DRENNAN ROAD CONNECTION FLOW CONTROL STATION

FOR THE SECURITY WATER DISTRICT

FEBRUARY 2017

**SITE DEVELOPMENT PLAN**

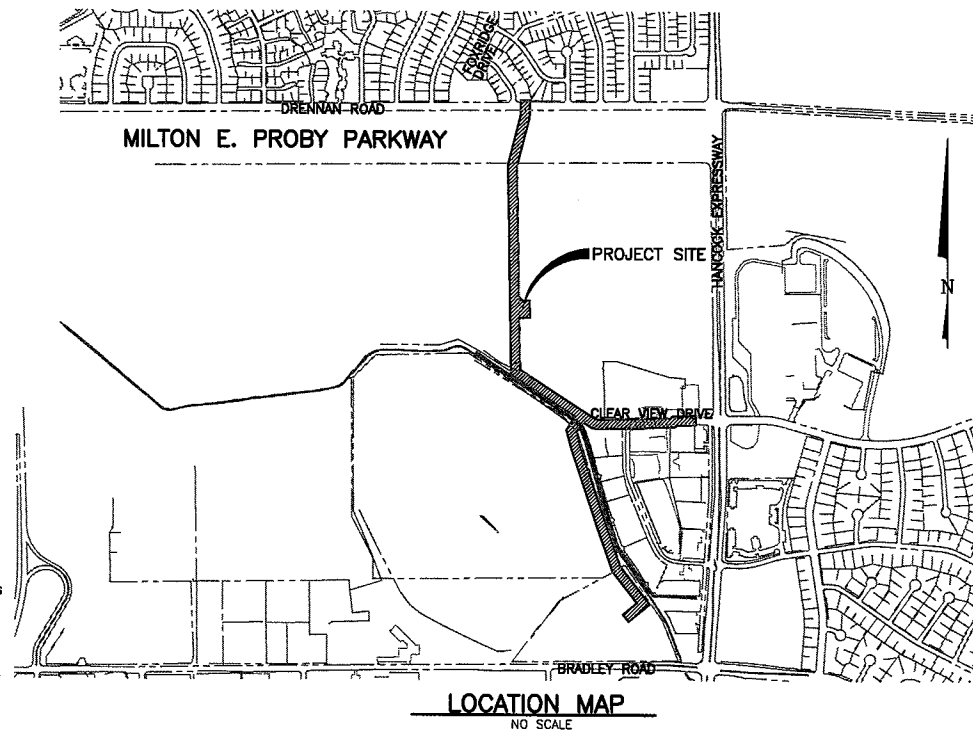
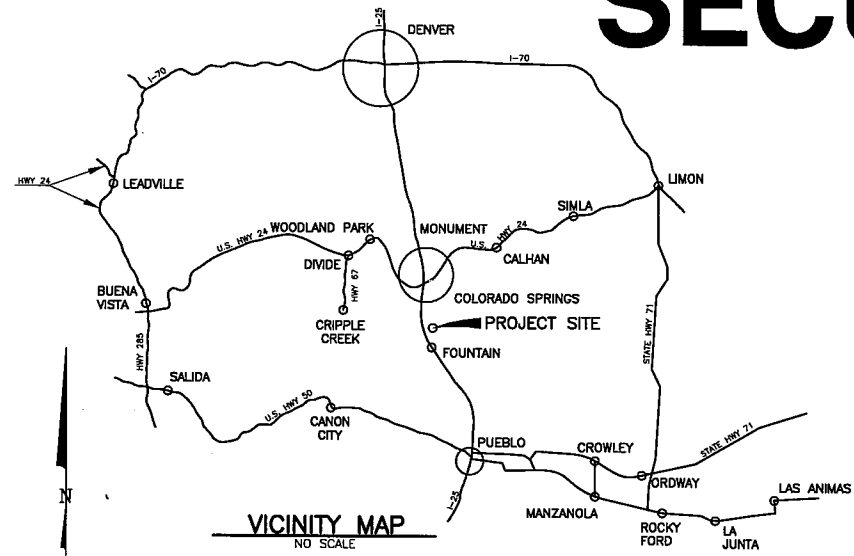
Remove the standard grading and erosion control signature block since site grading is less than 1 acre.
